KITTITAS COUNTY

MEMORANDUM

TO: Dusty Pilkington, CDS
FROM: Kelly Bacon, Engineer Technician I *KB*
DATE: July 15, 2016
SUBJECT: Bivens BL-16-00008

PART OF THE NORTHEAST QUARTER OF SECTION 31, TOWNSHIP 18 NORTH, RANGE 19 EAST, W.M.

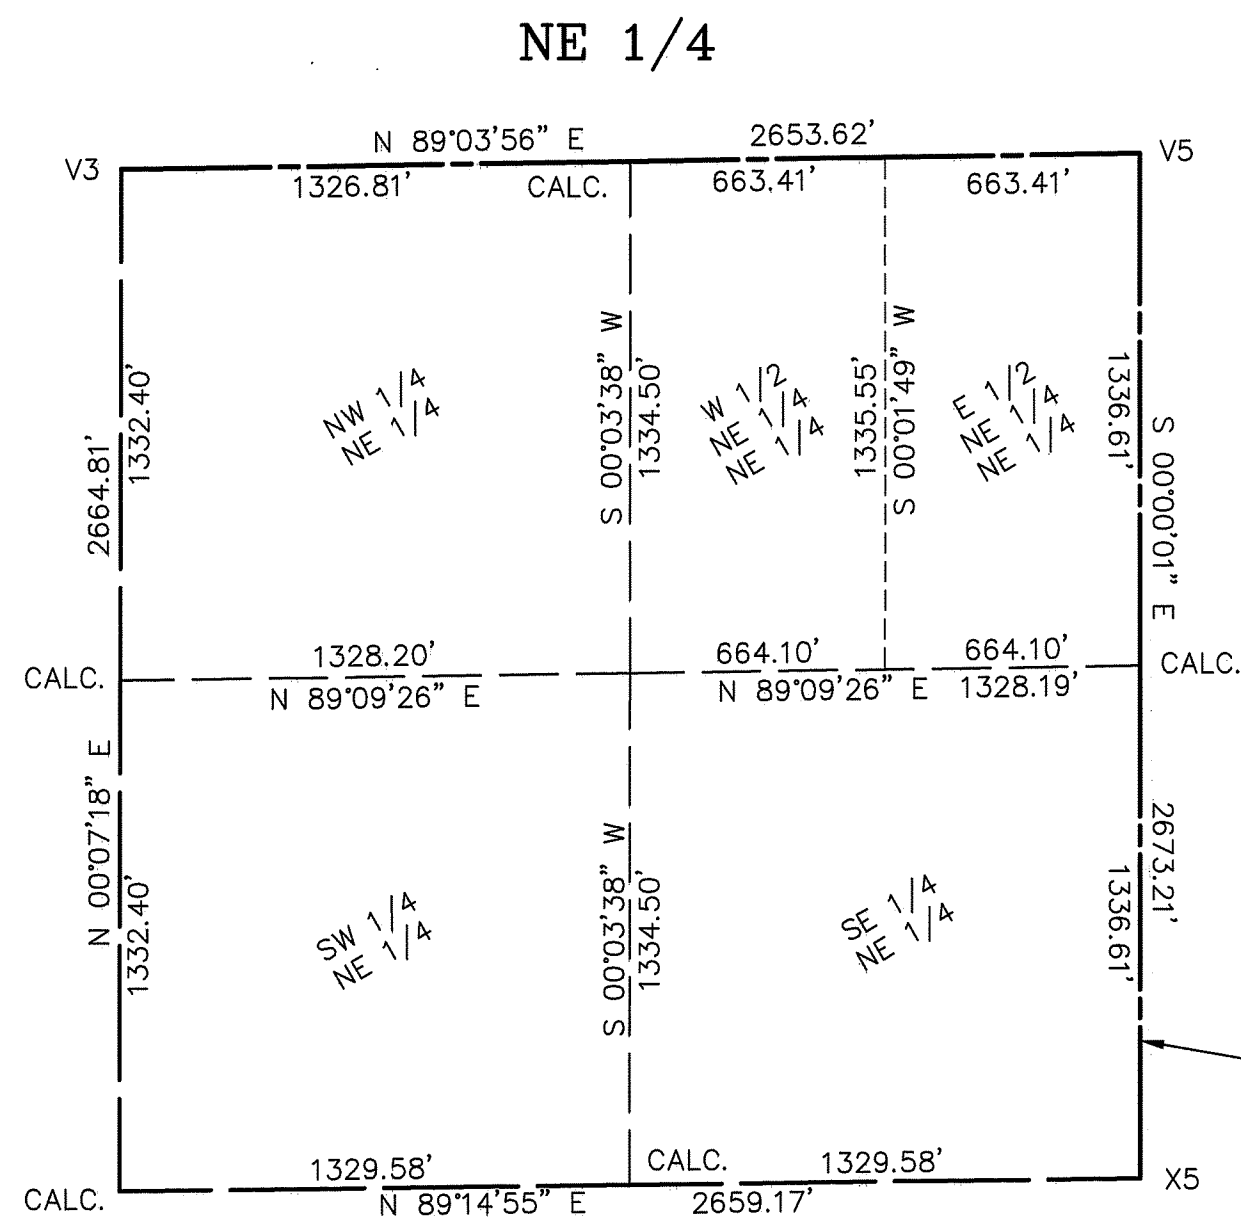
The Public Works Department has reviewed the Request for Boundary Line Adjustment and finds that the proposed access easement is only 20 feet wide. The minimum easement width required for a joint use driveway is 30 feet.

- a. The joint use driveway easement on the face of the BLA needs to be adjusted to a minimum of 30 feet wide.
- b. An approved access permit shall be required from the Kittitas County Department of Public Works prior to creating any new driveway access or performing any work within the county road right of way.
- c. Maintenance of driveway approaches shall be the responsibility of the owner whose property they serve. The County will not maintain accesses.
- d. Any further subdivision or lots to be served by proposed access may result in further access requirements. See Kittitas County Road Standards.
- e. Evidence of existing access and/or evidence of access to be created should be confirmed prior to sale of property.
- f. Access is not guaranteed to any existing or created parcel on this application.
